Date: 31 July 2026
Our ref: 554492
Your ref: EN010148

NSIP Reference Name / Code: Tween Bridge Solar Farm / EN010148

Title: Natural England's comments for Deadline 5 in respect of the Tween Bridge Solar Farm Project, promoted by RWE Renewables UK Solar and Storage Limited.

Figure 1: Non Breeding Bird Mitigation Plan

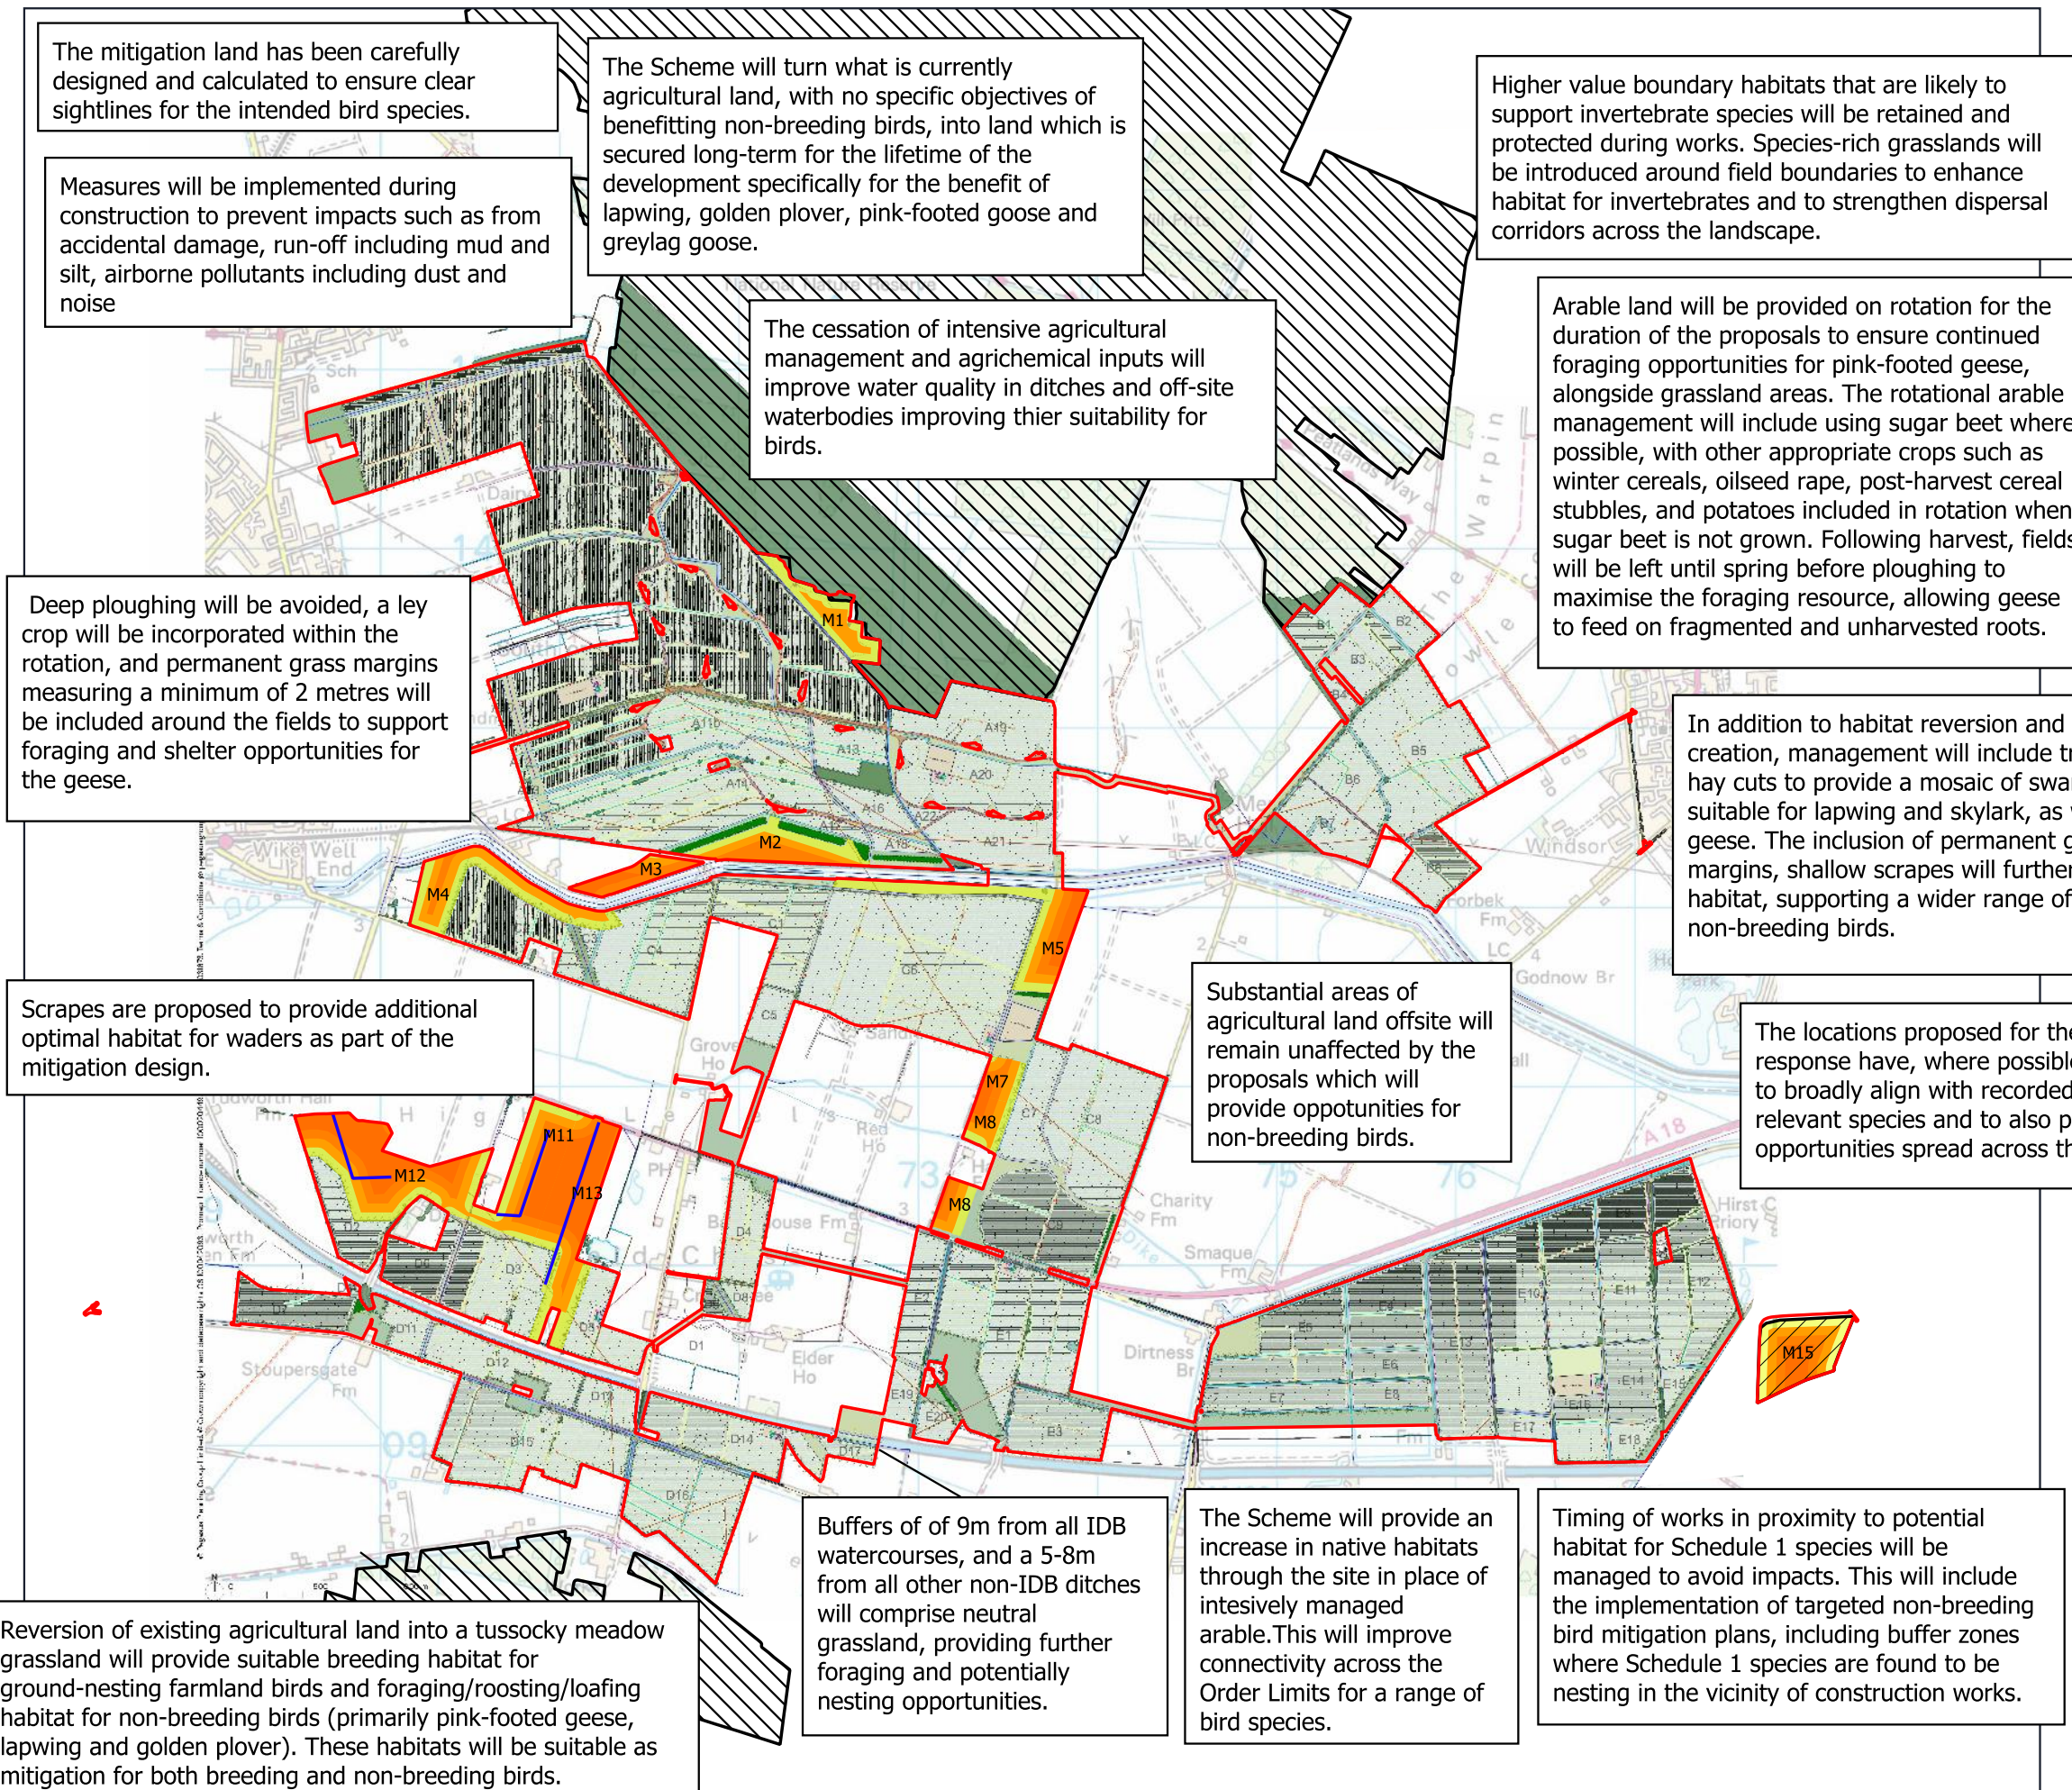
NE11a	International designated sites - Humber Estuary SPA - Humber Estuary Ramsar	Proposed management of mitigation area M1(A) (C) and (O)	<u>Please note NE11 has been separated into NE11a (Proposed management of mitigation area M1(A)) and NE11b (Potential hydrological impacts to SAC features) for this Deadline 5 response as the points in each section relate to different impact pathways for different sites.</u> In NE11 of our Deadline 3 response, we referred to comments in NE1a around potential impacts of the footpath on the suitability of the M1(A) site for SPA birds. Although M1(A) comprises part of the overall mitigation strategy/package for impacts to FLL for the Humber Estuary SPA/Ramsar, the Applicant has detailed that it is not relied on as a 'core' aspect (as summarised in 6.33 of the oLEMP). Therefore, we are satisfied that with the measures outlined in 6.33 of the oLEMP and other relevant sections of the HRA, the proposed footpath within M1(A) will not result in AEOI to the Humber Estuary SPA/Ramsar in this case. However, it continues to be our recommendation that re-consideration is given to the location of the footpath, if possible. For example, is there any potential for the path be re-routed to the edge of the parcel. Although the Applicant is not relying on this as a 'core' area of mitigation, this could enhance the function of the parcel for various bird species. Therefore, Natural England consider this to be a 'yellow' issue.	Yellow
